Applicant: Liv Chase - Sunny Time Solar LLC

Address: 48 Hancock St

Permit # 2015-00023

CHECK-LIST AGAINST ZONING ORDINANCE

20 FIRST FLOOR PLAN
 SCALE: 1/8" = 1'-0"

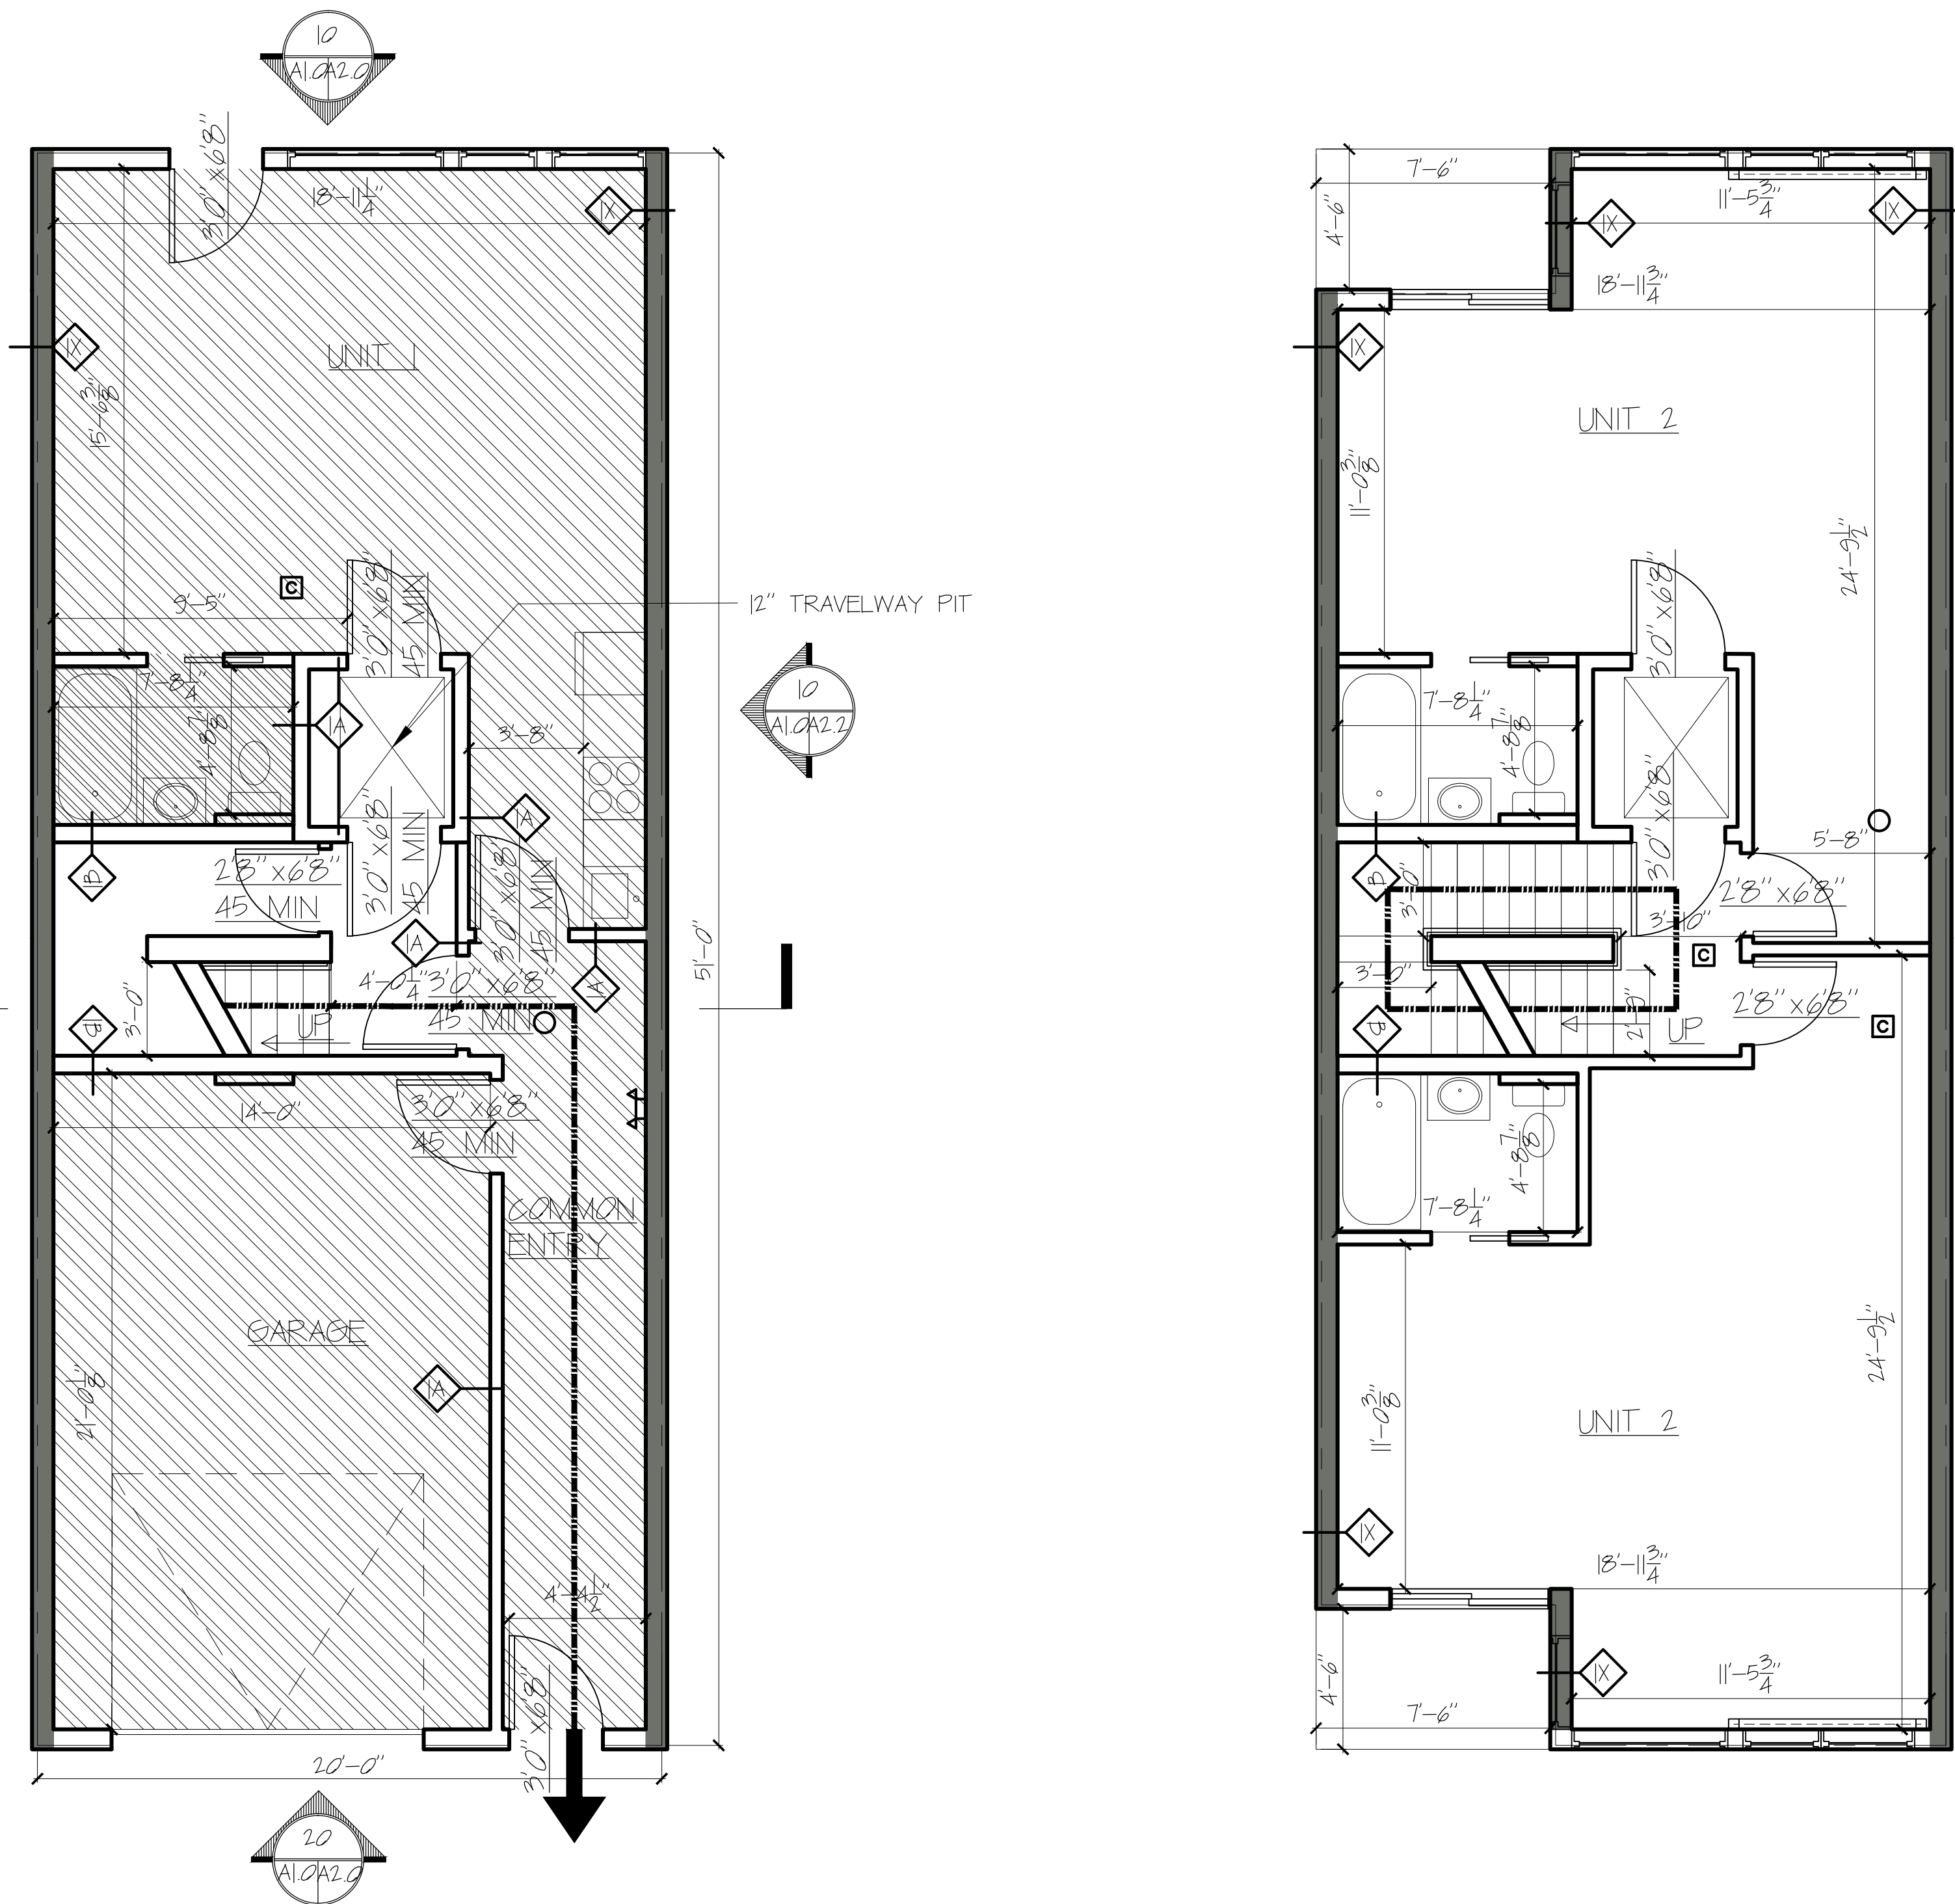
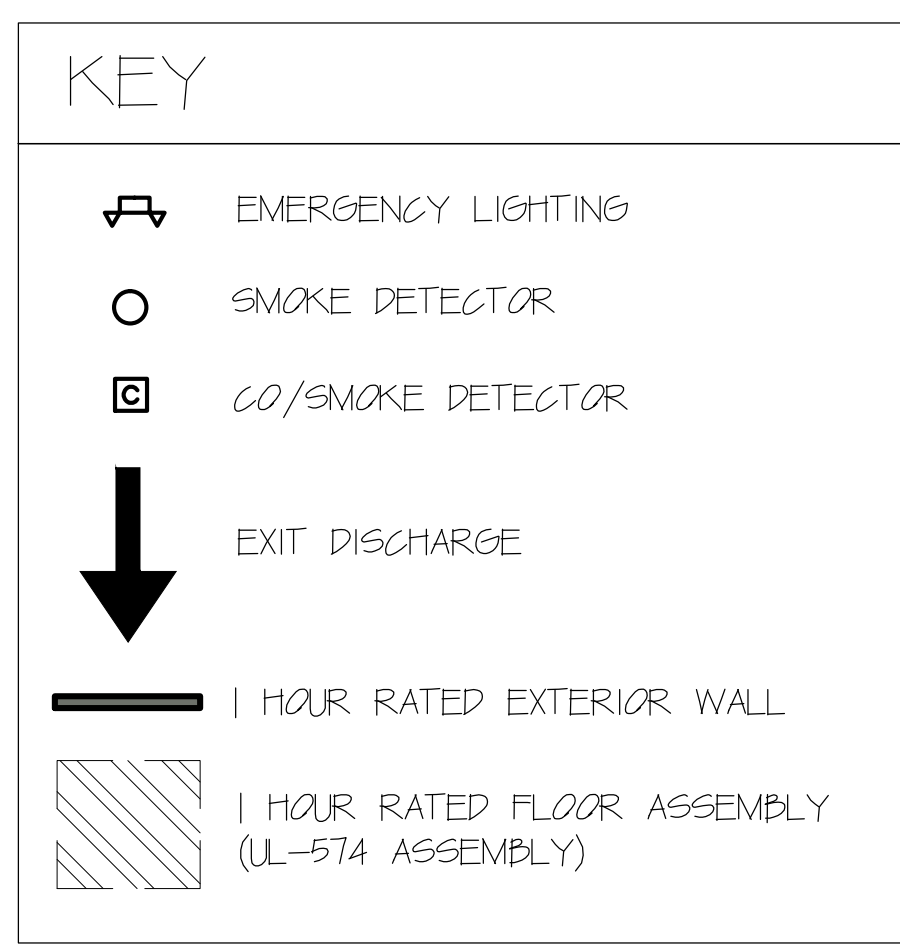
Proposed Use/Work - build a new 4 story duplex - 20' x 51' - 1st floor garage -

* Height - 45' max - 45' given to deck - in grade & same @ all 4 corners

Off-street Parking - 2 spaces - 1 space in garage 14' x 21' - parking legally & conforming OK
